Application for a non-material amendment following a grant of planning permission. Town and Country Planning Act 1990

Alteration of west elevation (front) from large window to include two smaller windows to accommodate addition of bathroom in first floor.

Old plan/drawing numbers: 003 - 8 Pboro Rd - 013 FF Plan - Proposed

New plan/ drawing numbers: WD - 003 - 8 Pboro Rd - 013 FF Setting Out 00

JOB		
8 Peterborough Road : WD 012 FF		
Setting Out Plan		
TENDER		
Scale(s)	Date	Drawn
1:50 @ A1	25/05/2014	K.M
Job No	Drawing No	Revision
003	013	C

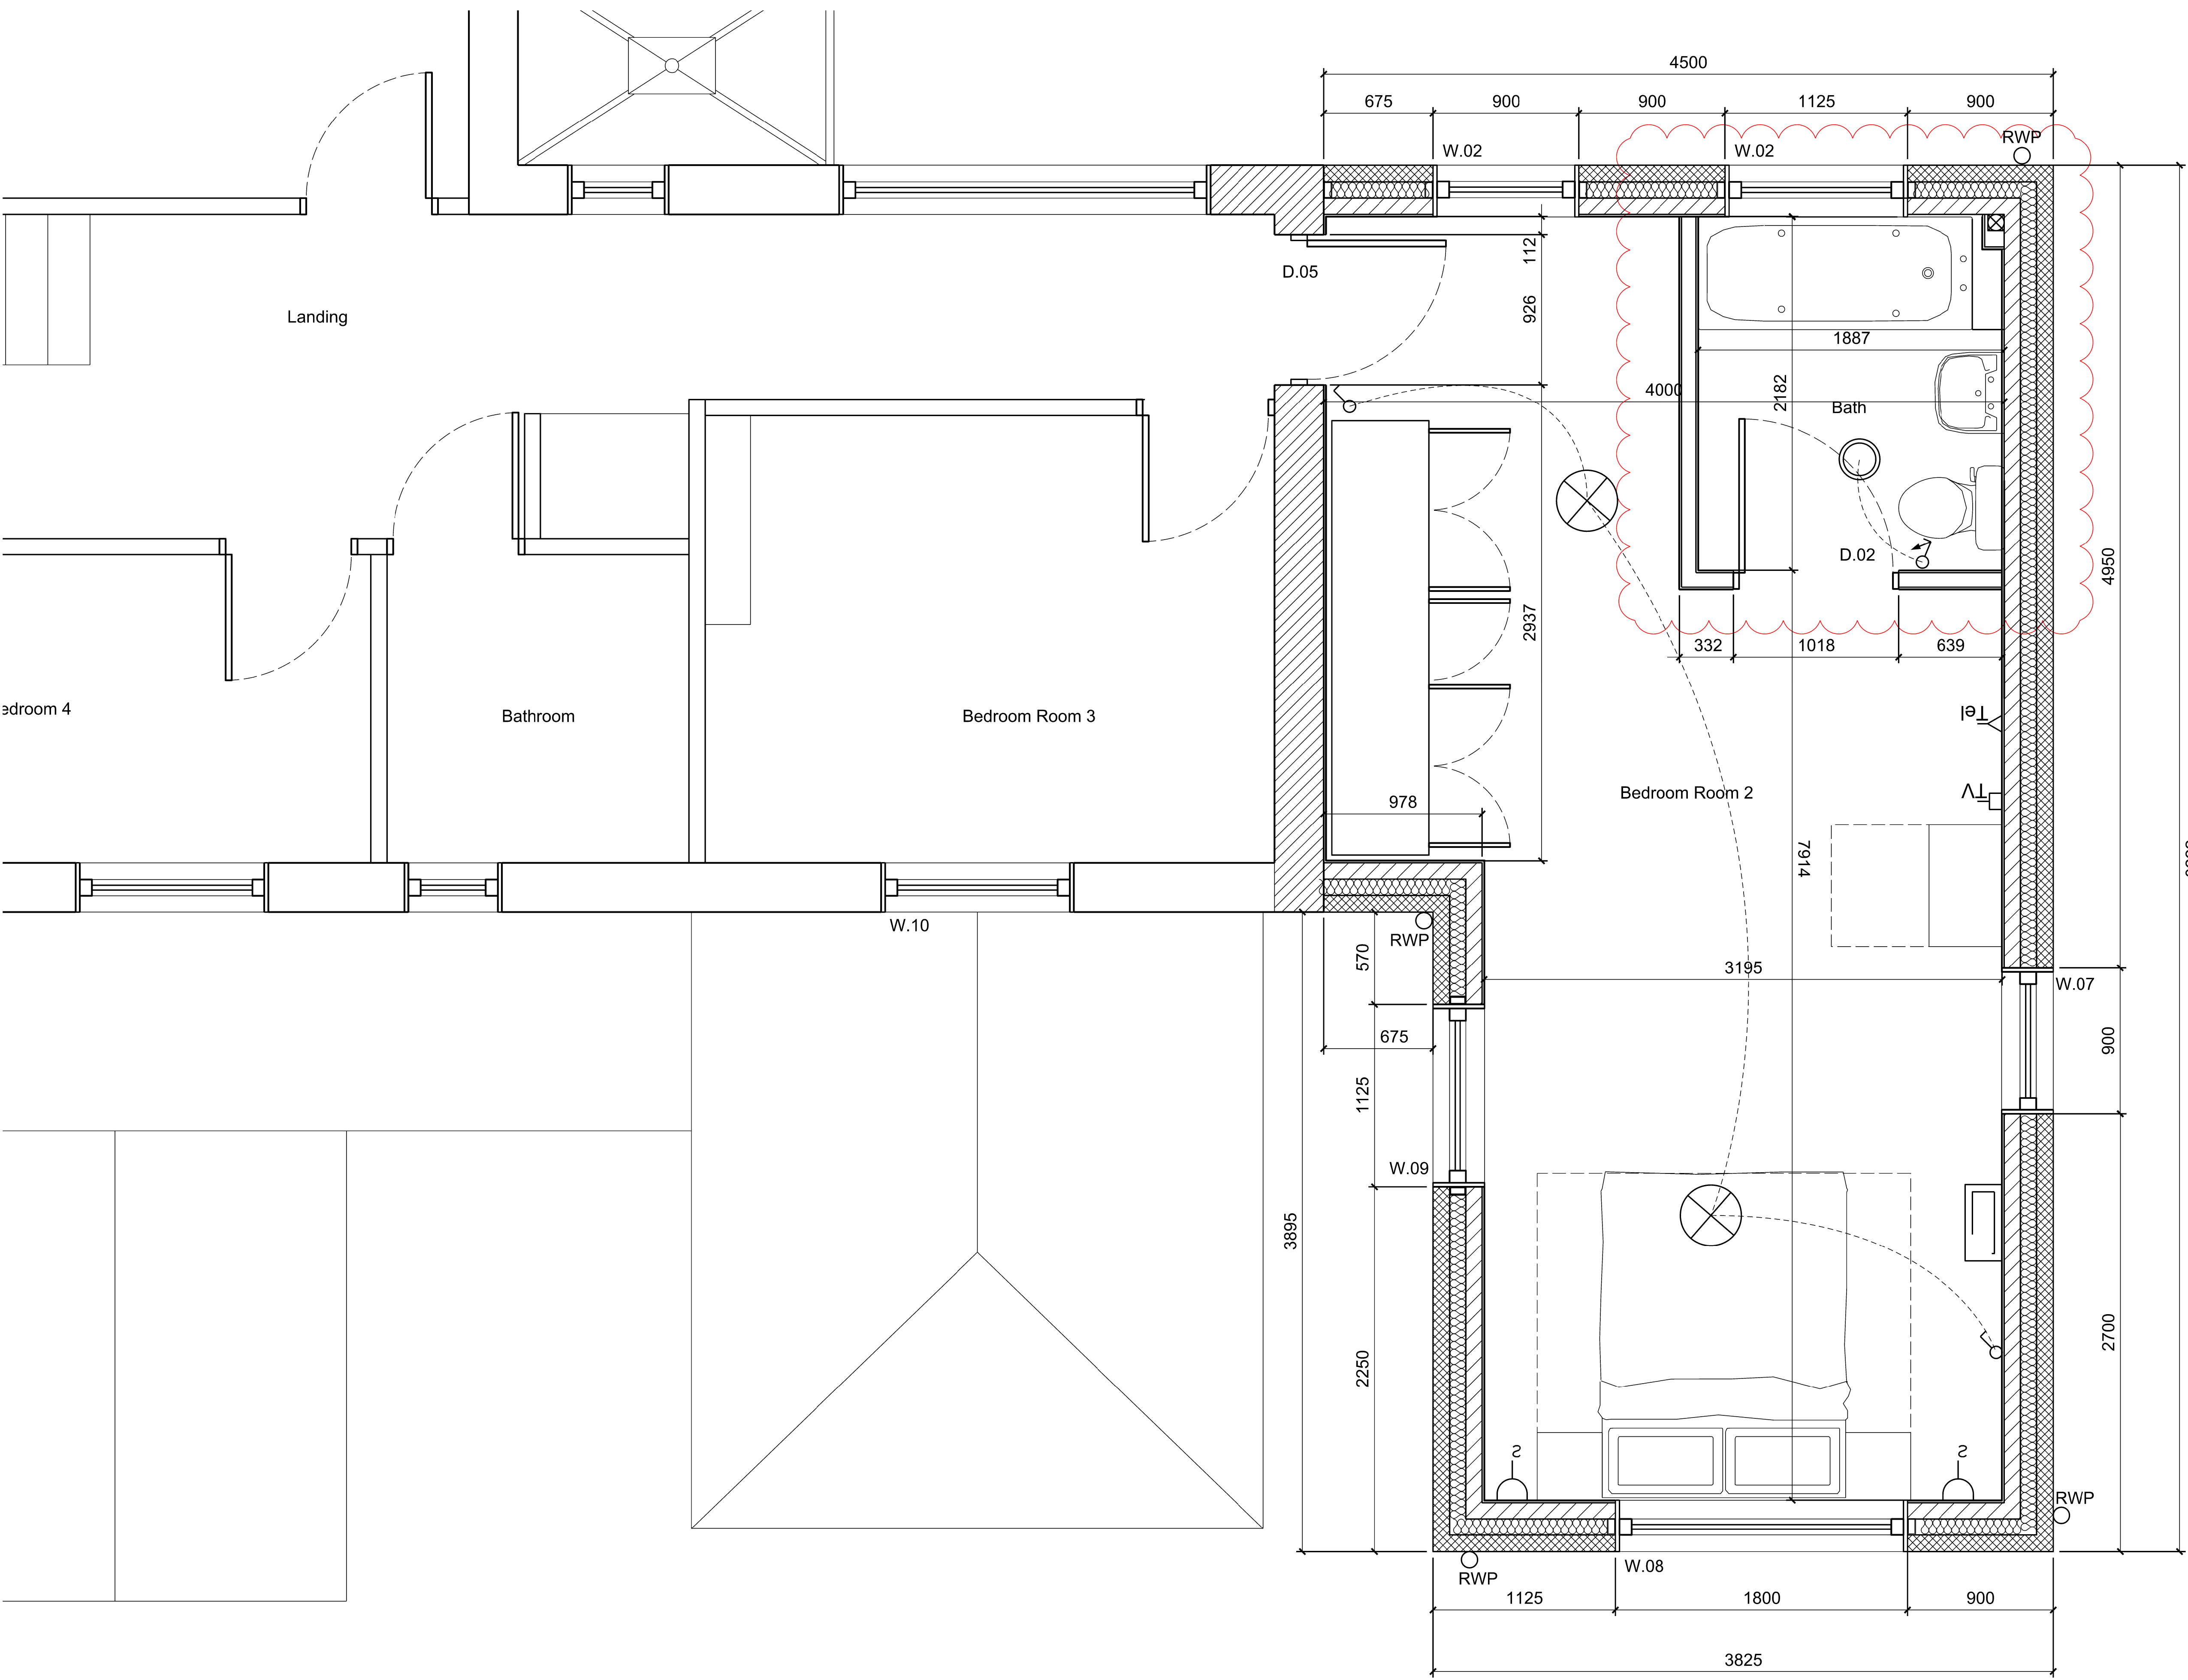
Elevation needs to accommodate the addition of a bathroom to first floor plan.
